Your Ref: OWPC15168
Our Ref: A/121/17/HH 21-06-2017
Please ask for:
Mrs A Gardner

11th August 2017

Detached double garage & single storey extensions to existing garage.
Harcourt West Drive Angmering

<table><tr><td>PROJECT HARDCOURT West Drive, Angmering Littlehampton. BN16 4JE</td><td rowspan="4"> 29 Breach Avenue, Southbourne, Emsworth, Hampshire. PO10 8NB T: 01243 697164 M: 07879471666 www.pdkconsulting.co.uk</td><td rowspan="4"> PDK Architecture and Surveying</td></tr><tr><td colspan="2">DRAWING PROPOSED SITE PLAN</td></tr></table>

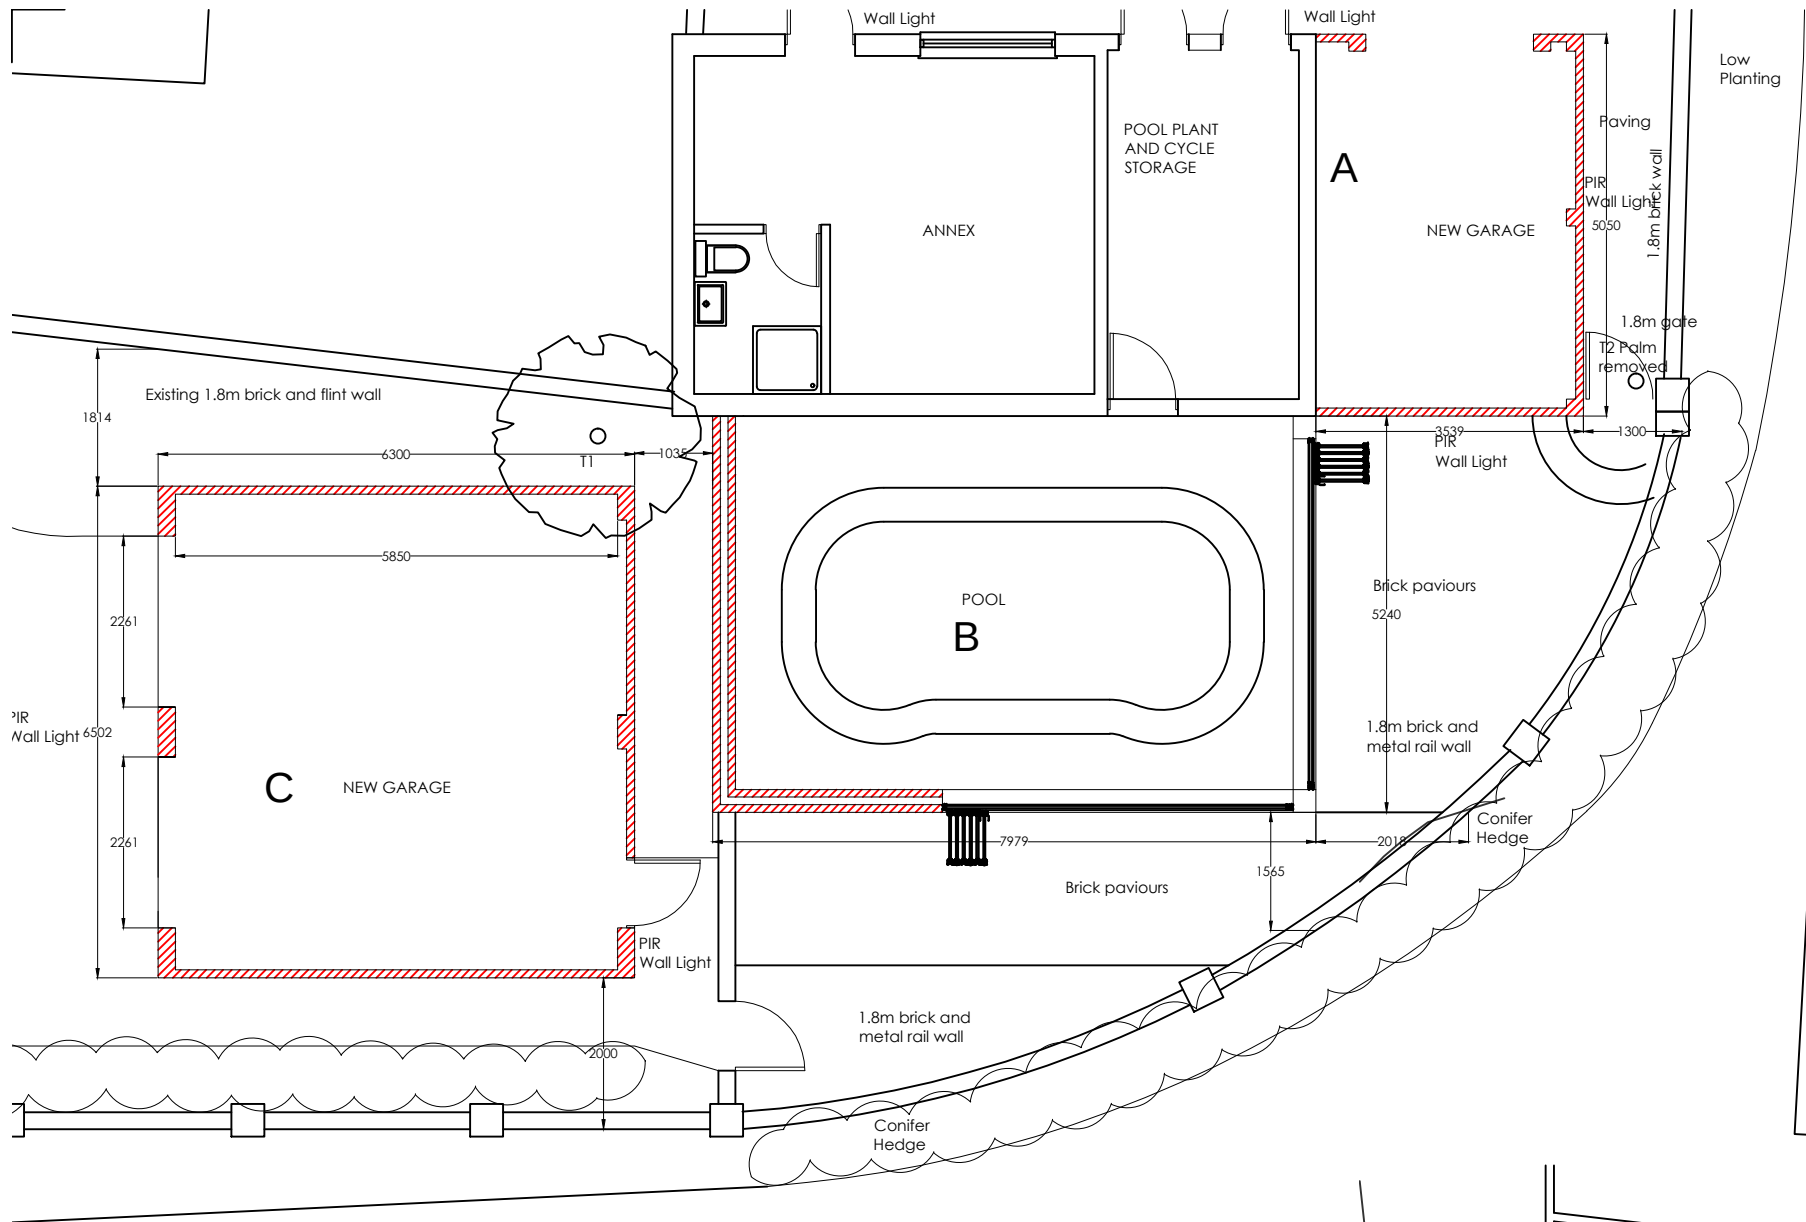
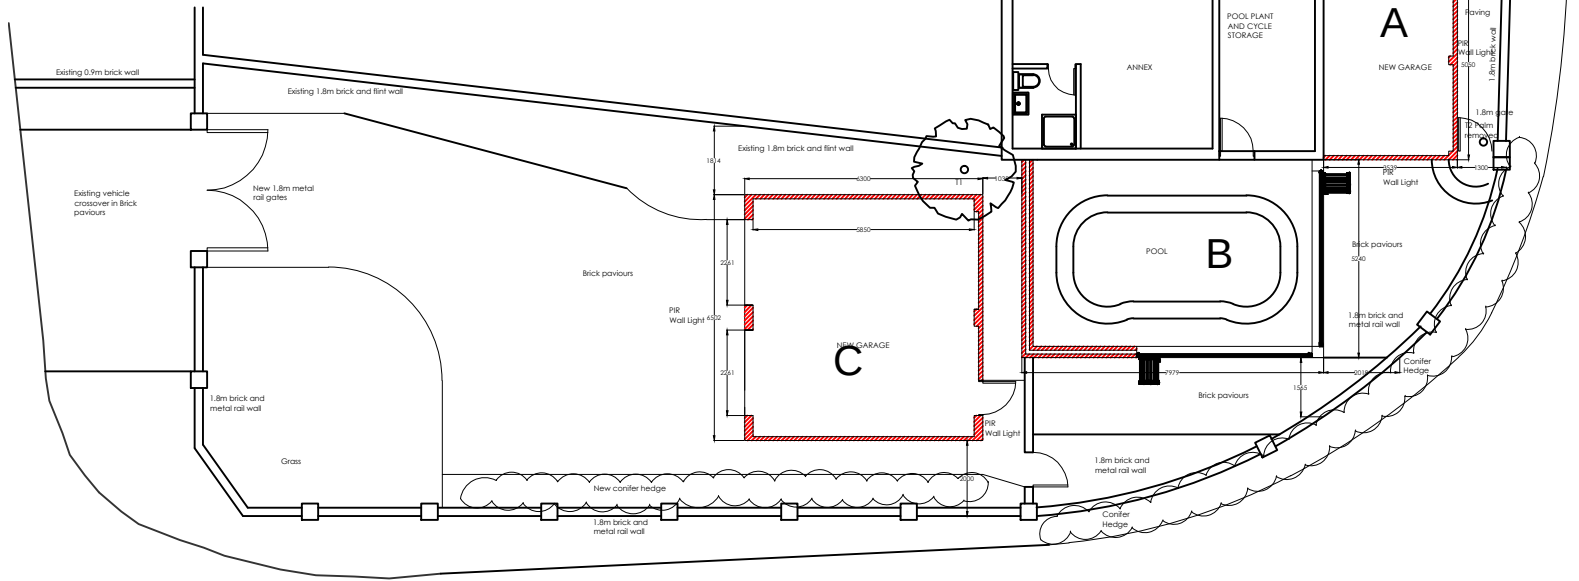
My concerns with this application are; The access point which is onto a junction. The proposed new garage is outside the building line and could create a precedent for garages to be built on the opposite side of the road. A separate dwelling could be created by transforming the extended garage into a bungalow. I do not object to the extension of the existing garage.
